To: The Planning Inspectorate examining the Boreas DCO Application.

Necton Parish Council would like to make a comment on the Vattenfall reply to the written question URN: 9.2.8, Siting of the Substations at Necton

8 January 2020

SCENARIO 1
Figure: 29.28b (1 of 2)
Viewpoint 6: A47 Top Farm

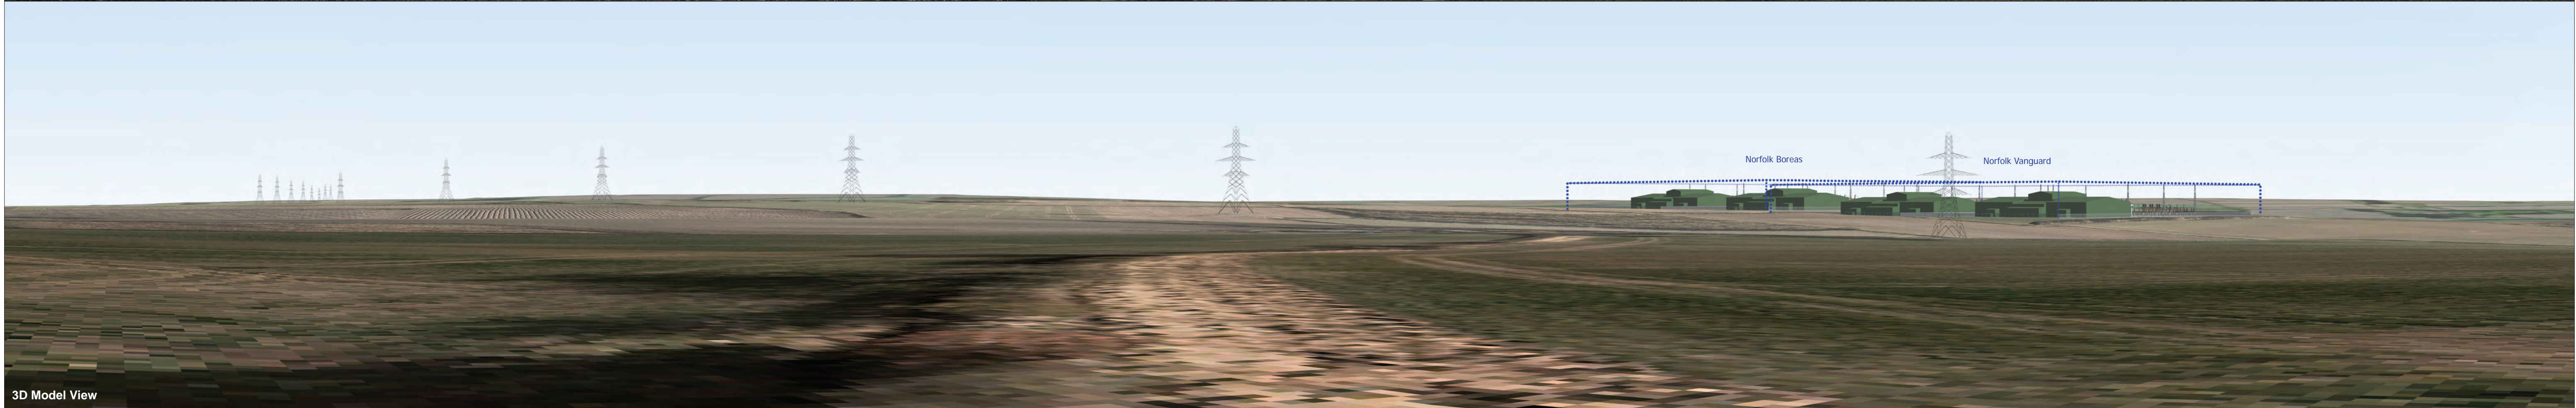
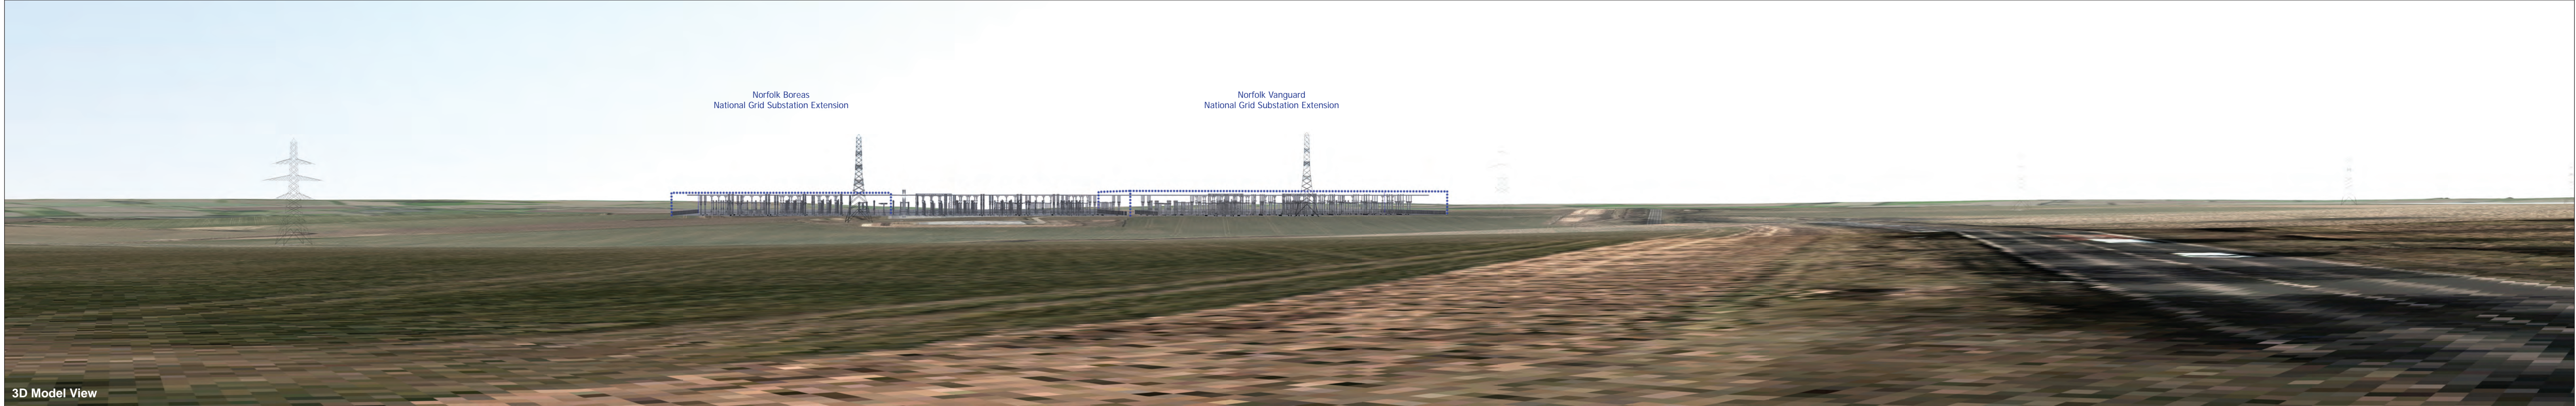
Necton Parish Council do not believe that these answers are accurate. We would dispute that the site chosen for the converter halls is on lower land than the alternative Top Farm land proposed by us. We have looked in detail at the Ordinance Survey maps and we have walked on the ground.

From both the OS maps and visually, we can state that the site chosen is on contours 70 – 72 metres which is the highest point in Necton. The Top Farm land which we proposed to Vattenfall during the consultation process lies on contours between 60 and 62 metres which is considerably lower. Top Farm itself is higher than the land that would be used for the substations.

We understand that the site we would prefer is not as flat as the site chosen by Vattenfall. In view of the fact that this will be the largest substation in the world, cost should not be the prime consideration with regard to the site. The fact that mitigation will be possible on the lower site and not possible on the higher site should also be an important factor.
